CITY OF ALBUQUERQUE

**RE: Transport Housing Apartments
Conceptual Grading and Drainage Plans
Engineer's Stamp Date: 08/25/21
Hydrology File: M15D023H**

**RE: RESPONSE TO HYDROLOGY COMMENTS
TRANSPORT HOUSING APARTMENTS, 2900 TRANSPORT ST. SE
CONCEPTUAL GRADING & DRAINAGE PLAN**

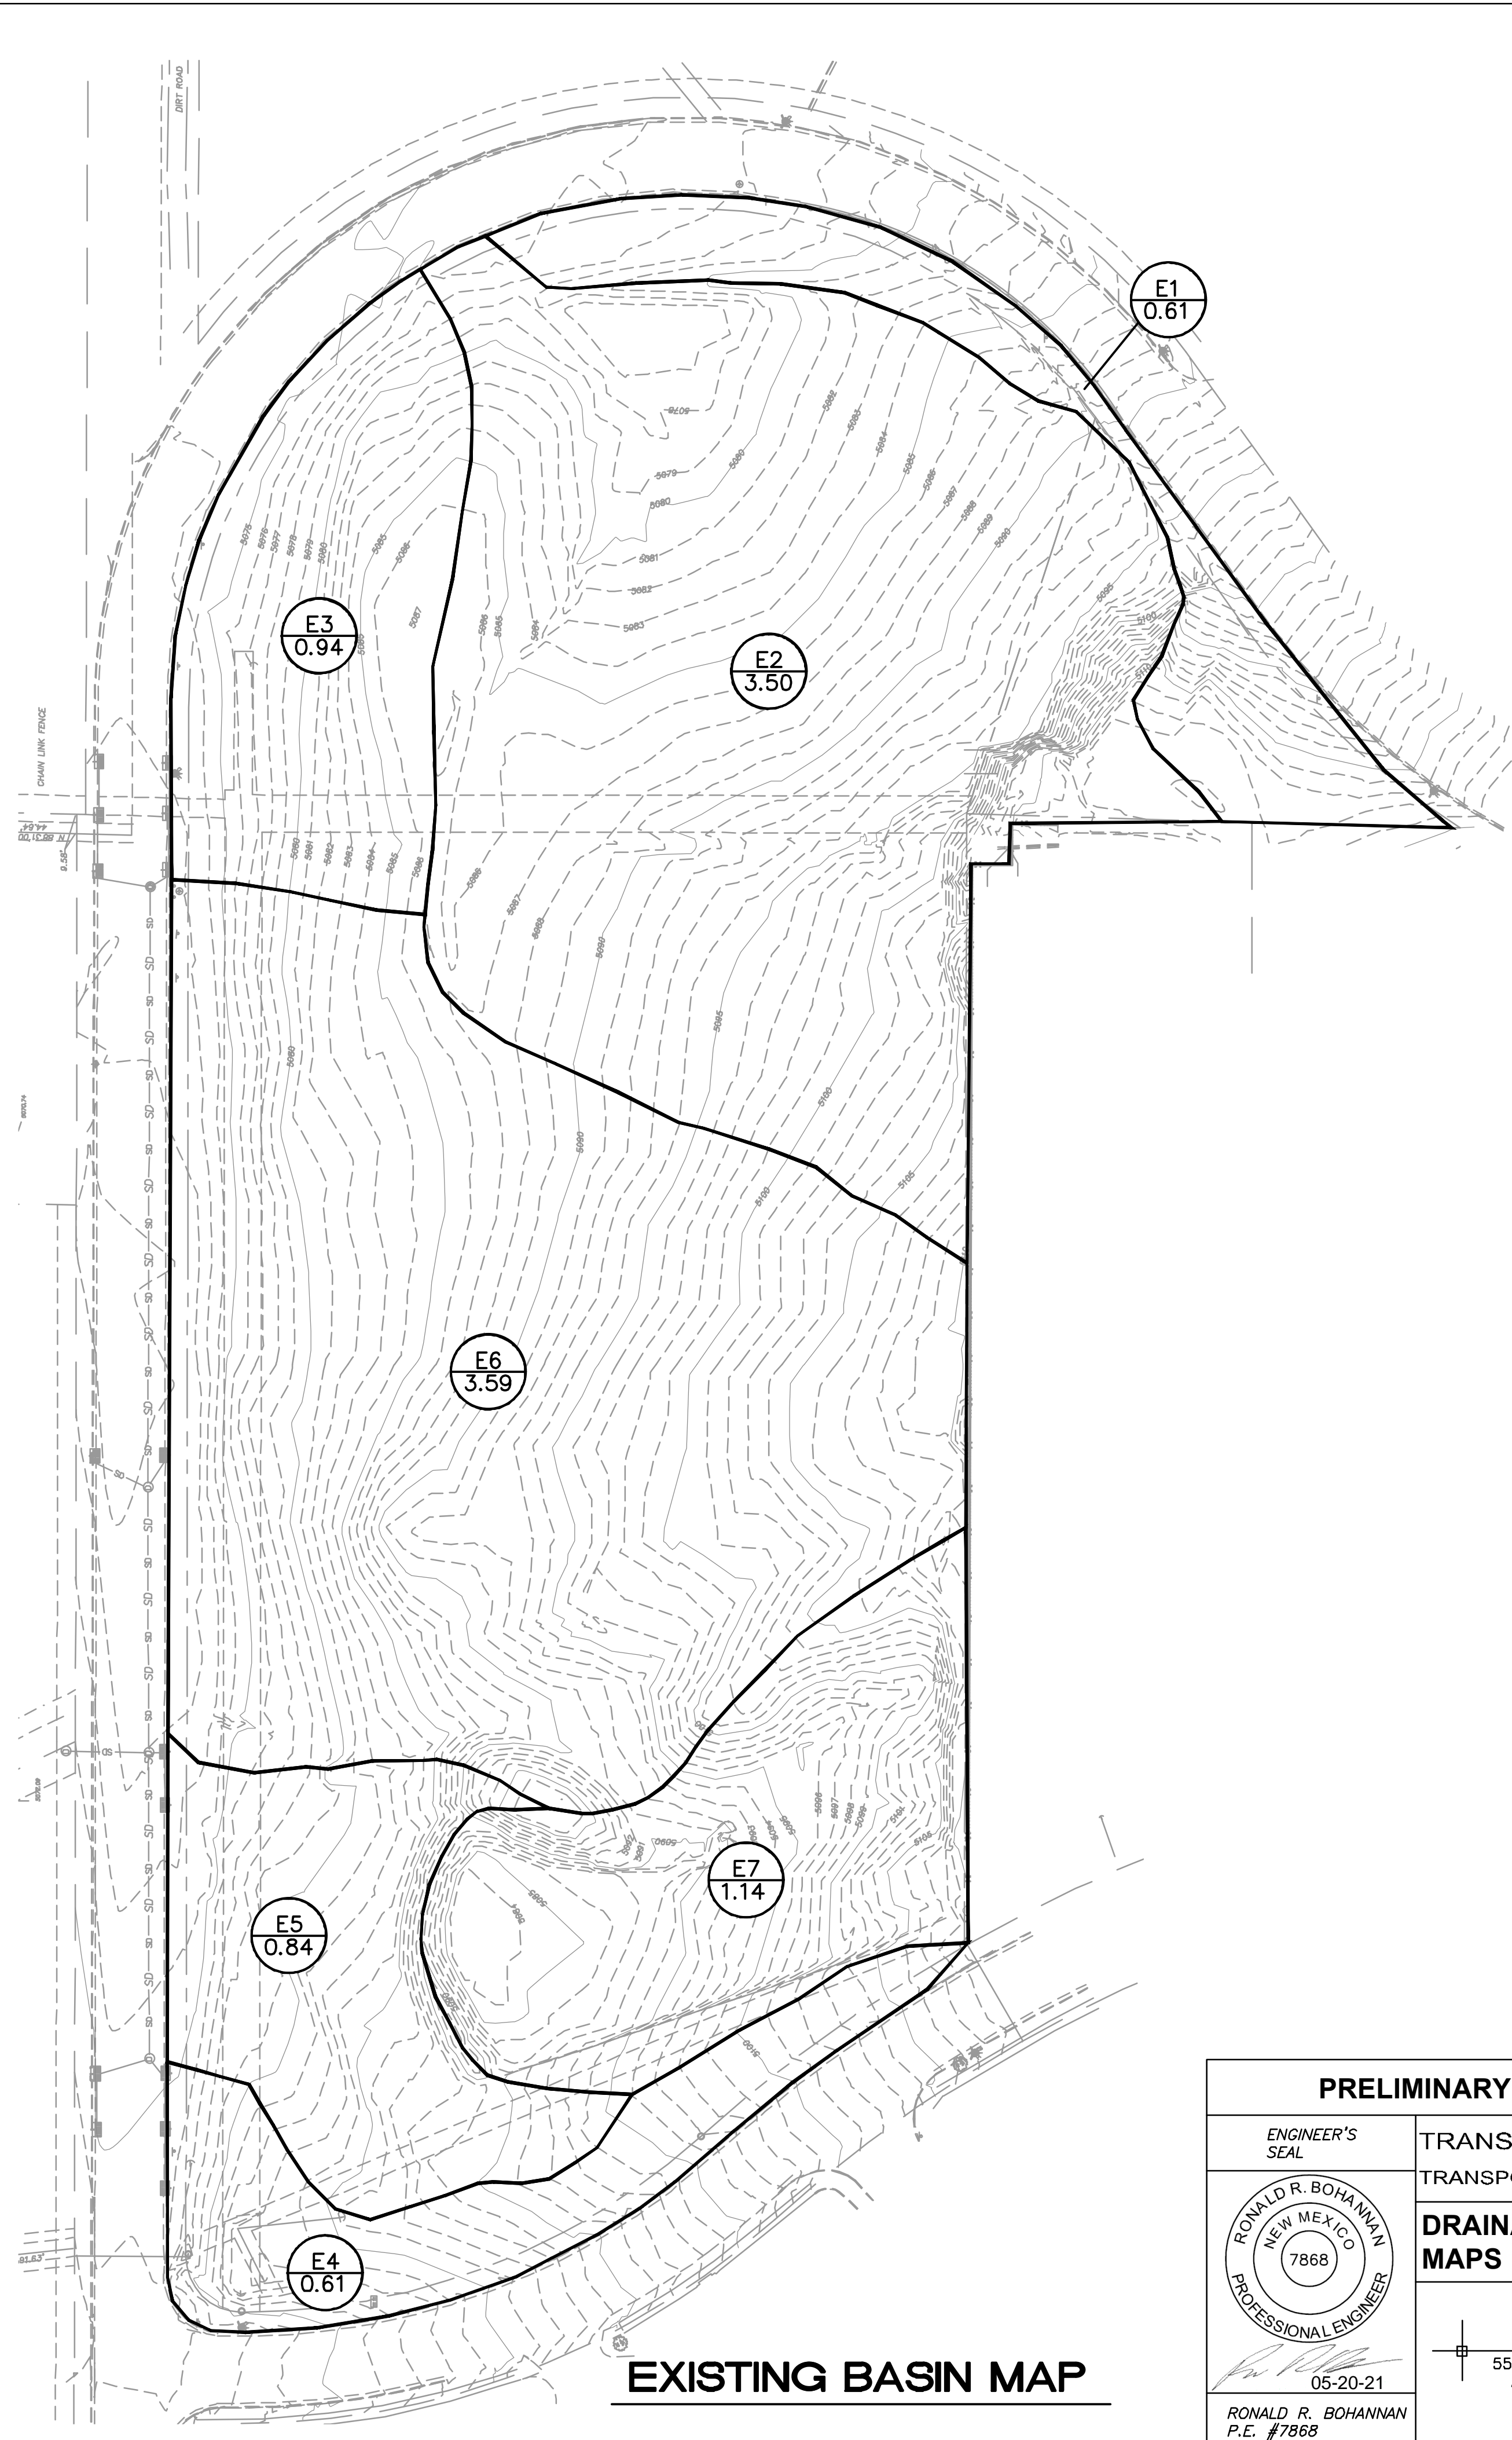
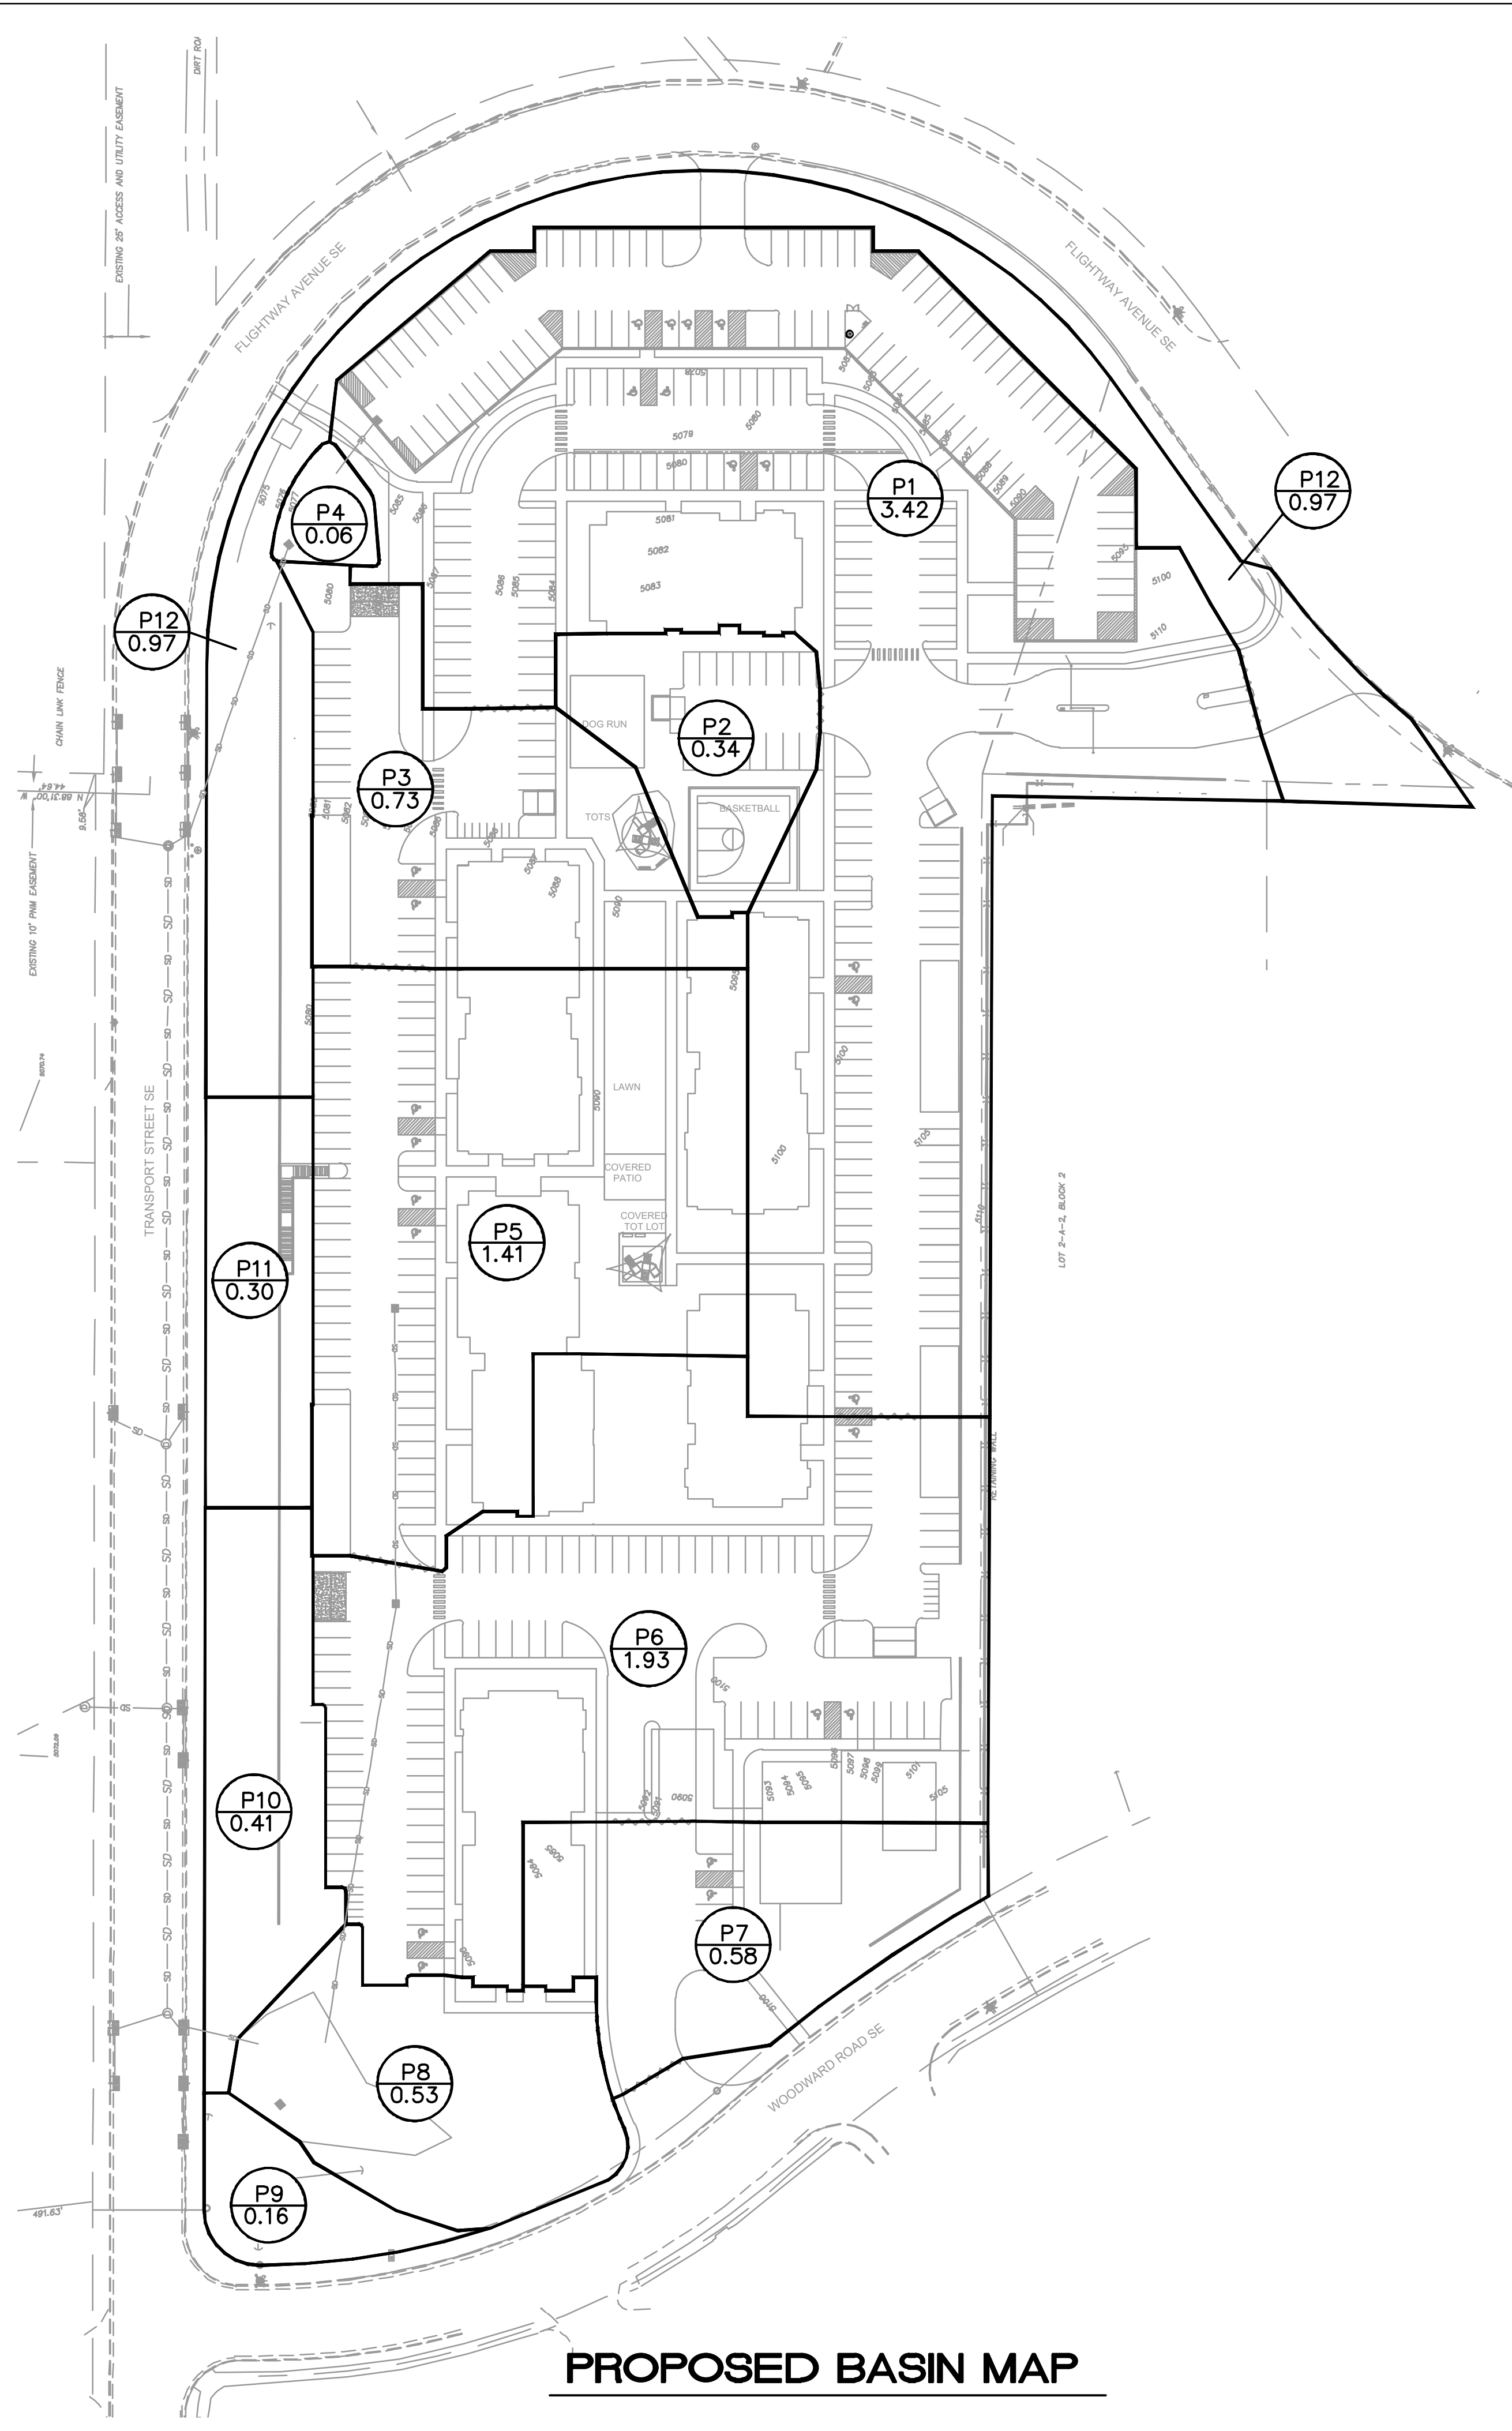
1. Sheet 2.2. Please add the existing basins that correspond to Sunport Phase 1 Master Drainage Plan to both the existing and the proposed basins.
Response: These basins are now shown on both basin maps on Sheet 2.2.

4. Sheet 2.2. Please add some drainage arrows on the proposed drainage basins showing how each area will drain to the respected detention pond.
Response: Flow arrows have been added to the proposed drainage basin map.
